1950 Scott Street | *Formal Review* | Zoning Amendment to construct a 20 storey residential building | NEUF Architect(e)s; EBC Inc.; Fotenn Planning + Design

Figure 13: North Elevation Drawing

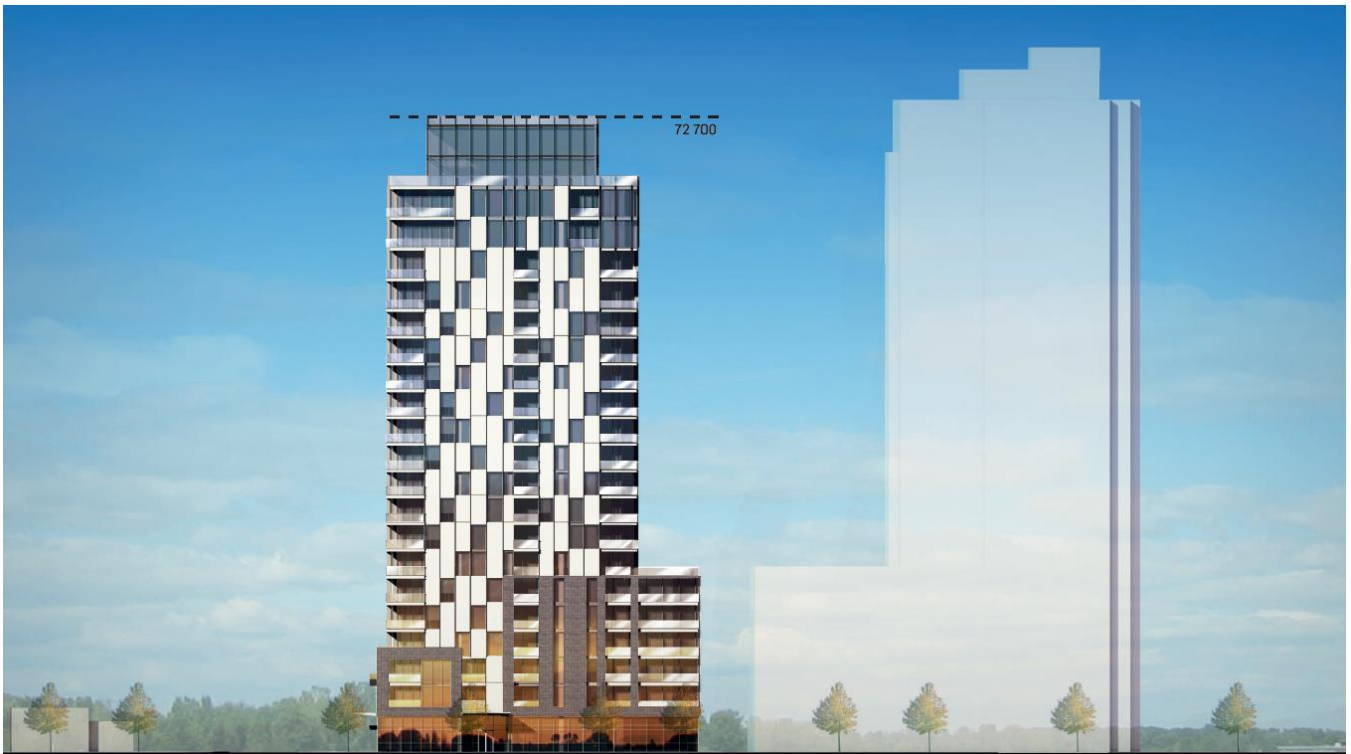
- The Panel finds there is a lack of connection between upper portion of the building and the ground plane. Find opportunities to carry some elements from the podium up the building, and increase the width of the podium relative to the tower, to add depth between the podium and the tower above.
- The Panel suggests one consistent podium along Scott Street, which wraps around Clifton, ending at the vertical break in the building. Beyond this strong vertical break (p.24), a lower three storey podium could continue along Clifton, in order to relate the building to the low-rise residential neighbourhood to the south.
- The Panel recommends that the podium should have a unique expression to distinguish itself from the rest of the building. For example, avoid copying the balconies from above, on the podium level – ensure a different language that clearly distinguishes the podium from tower.

- The Panel recognizes the challenge of achieving good proportions, given the relatively low height of the building, and the comparatively large floorplate.
- The Panel recommends a simpler expression of the tower, where volumes are more clearly differentiated, particularly by introducing a step back above the podium (indicated on p.14 & 15).
- The Panel suggests eliminating the checkerboard pattern. Instead, consider introducing a strong masonry piece in the middle portion of the building. Simple, vertical expression on all four sides of the building will improve proportions, and

the articulation of the corner. A specific suggestion from the Panel to consider is the introduction of a vertical red line – with two separate treatments - one to the east and another to the west.

- The Panel finds the expression of the top of the building to be somewhat bulky. Explore ways of lightening the top.
- The Panel is quite appreciative of the simple vertical solids shown on the sketch on p.15.
- The southwest elevation shown on p. 26 exemplifies that architecturally there is competition between the vertical and horizontal elements. Simplify these expressions, and consider that the seams on the white cladding panels could be problematic.
